From: Philip Trueman <ptrueman@hesterarchitects.co.uk>
Sent: 29 April 2021 17:29
To: Richard Phillips
Subject: RE: Morrison Supermarket, 41 - 67 High Street, Yiewsley
Attachments: 16128 - 2 - 631 - Podium Privacy Screen Details.pdf; 16128 - 2 - 630 Rev A - Privacy Screen Details.pdf

From: Richard Phillips <RPhillips@Hillingdon.Gov.UK>
Sent: 29 April 2021 16:04
To: Philip Trueman <ptrueman@hesterarchitects.co.uk>
Subject: Morrison Supermarket, 41 - 67 High Street, Yiewsley

3 Balcony Privacy Screen - Elevation

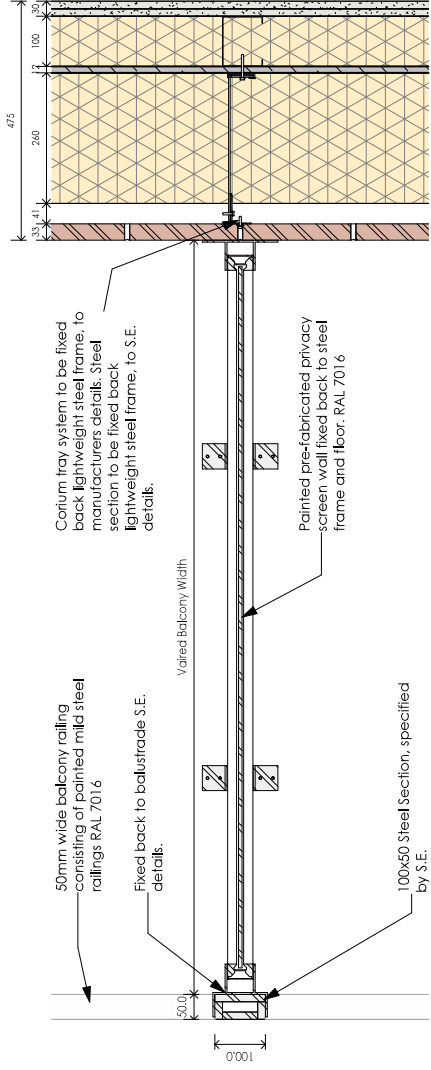
As regards details in relation to Condition 10 (Details of the Privacy Screens / First Floor Amenity Areas Boundary Treatment), the condition does require details of the boundary treatment of the first floor amenity areas to be submitted in order to prevent overlooking to neighbours, particularly the adjoining school from the use of these areas but no details have been submitted.

In addition to the units specifically mentioned in the condition (CO2, CO6, C13, C17, C24, C28 & C35), Drw. No. 2 – 630 also shows other balcony areas highlighted in red but not sure why and no corresponding privacy screen detail is provided. Happy for these balconies to be omitted, but that said, I think it would be useful to have details of privacy screens along the side where two balconies immediately adjoin each other.

With regard to Condition 10 I have attached the proposed detail at the edge of the podium which screens the overlooking toward the school drawing 631. The adjoining balcony screen detail is shown on the drawing 630 – we are proposing a 1.8m high metal screen consisting of 45 degree vertical louvres between balconies.

The units mentioned in Condition 10 - **CO2, CO6, C13, C17, C24, C28 & C35** will have full height screens of the same kind at the end of the balconies to prevent over-looking, as will flats **B09, B18, B27, B36, B42**. I hope this is clear from my mark-up but please let me know if you need any more information or details.
